RE: Project File Number, Brown and Jackson, SE-20-00003

Our written comments submitted are in regard to Washington State Environmental Policy Act (SEPA), Chapter 43.21C RCW, and Kittitas County Grading Permit public notice Brown and Jackson, SE-20-00003, dated, Monday, August 17, 2020. It is of our understanding that Kittitas County is acting as SEPA Lead Agency for the proposed project and proposed SEPA project actions and that Kittitas County is reviewing Brown and Jackson's June 11, 2020 Kittitas County, Department of Public Works, Grading Permit Application. However, based on review of the documents we understand we are commenting on the project as a whole, including, but not limited to, SEPA determination for Washington State Department of Ecology's General Permit for Biosolids Management.

**BROWN & JACKSON**  
 Land Application Site  
 Preliminary  
 Site Map  
 Kittitas County  
 Washington

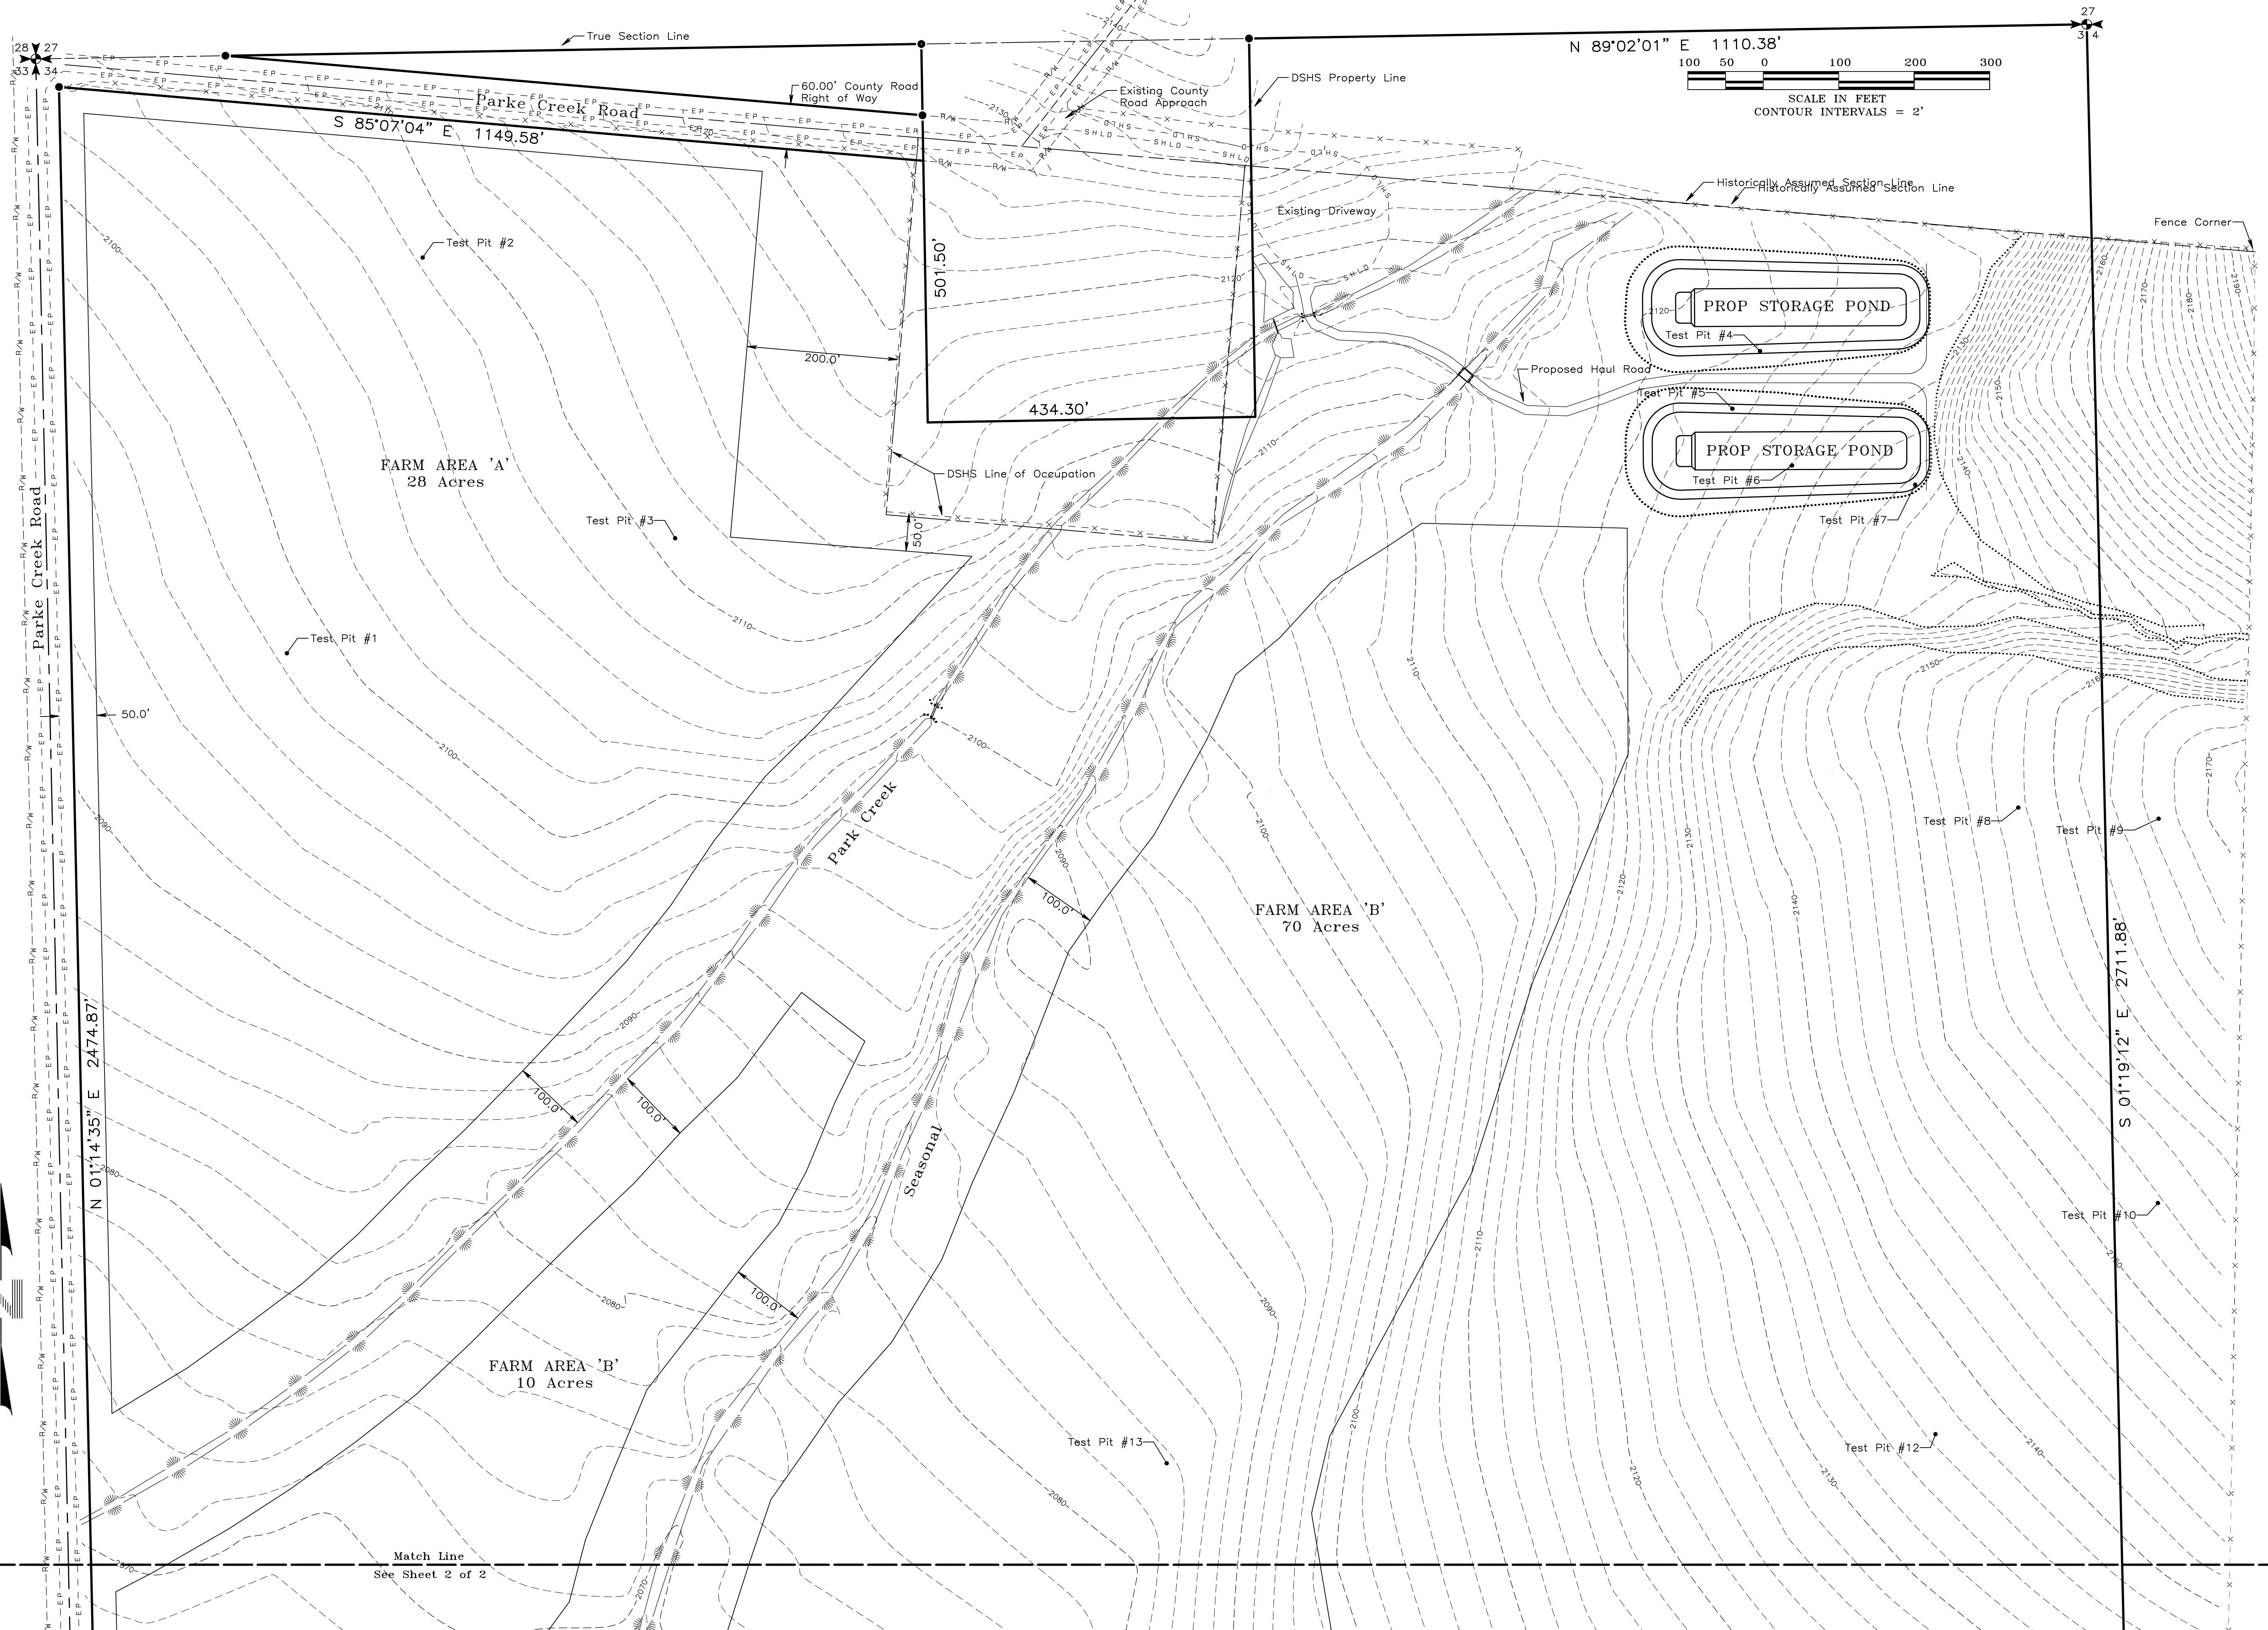
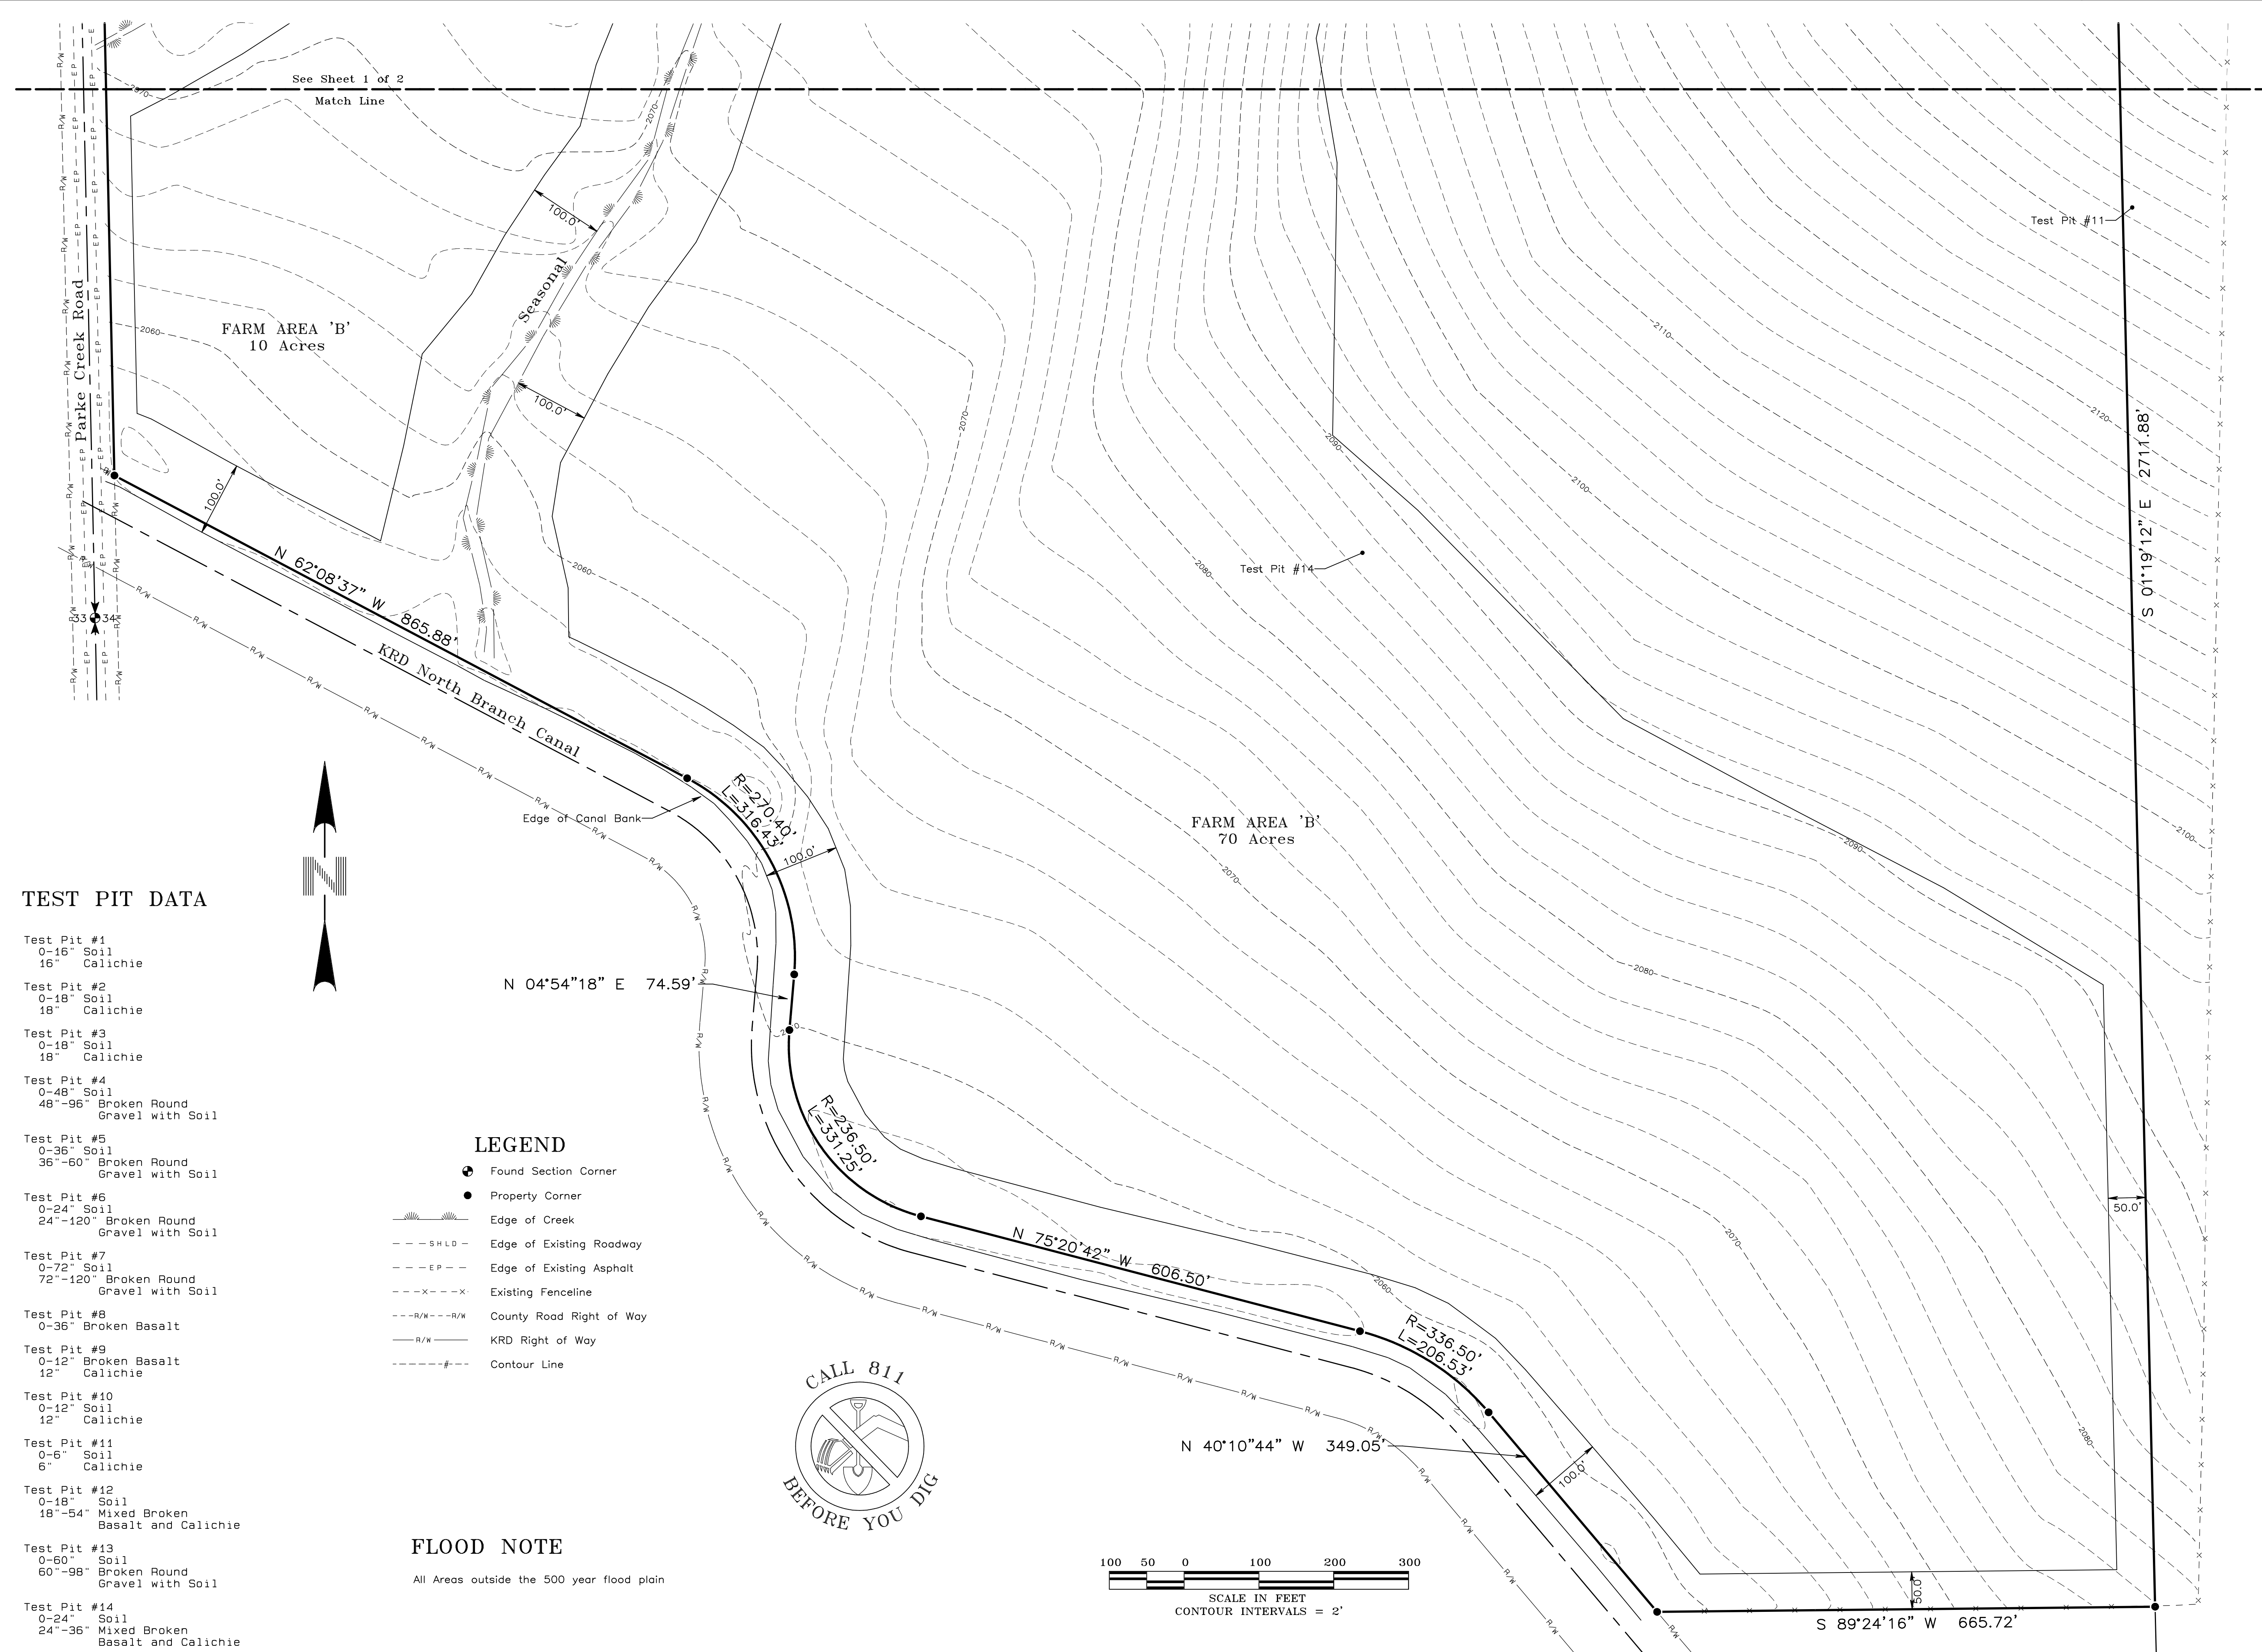
A.12.: Included Preliminary Site Plan does not appear to locate features, such as streams and irrigation ditches accurately. Included map in the July 30, 2020 Western Pacific Engineering and Survey document improperly characterizes Parke Creek’s location with respect to the fields and proposed storage ponds. Parke Creek is the water body flowing from the north to south on the eastern-center portion of the site. The irrigation ditch, locally known as Parke Creek Ditch, flows from the east to the west across the site conveying irrigation and stock water to farms and ranches several miles downstream of the site. Please update maps and labeling.

A.1.: Parke Creek Ditch flows east to west diagonally across the project site. Parke Creek flows north to south across the project site. KRD North Branch Canal immediately abuts the project site to the south. 3 surface water bodies, total. Please update.

B.1. Answer provided is incorrect. The Parke Creek Ditch and KRD North Branch Canal are either within or immediately adjacent to the project. Describe how any runoff or over application of septage will directly impact 1,000's of acres of highly valuable farmland and crops.
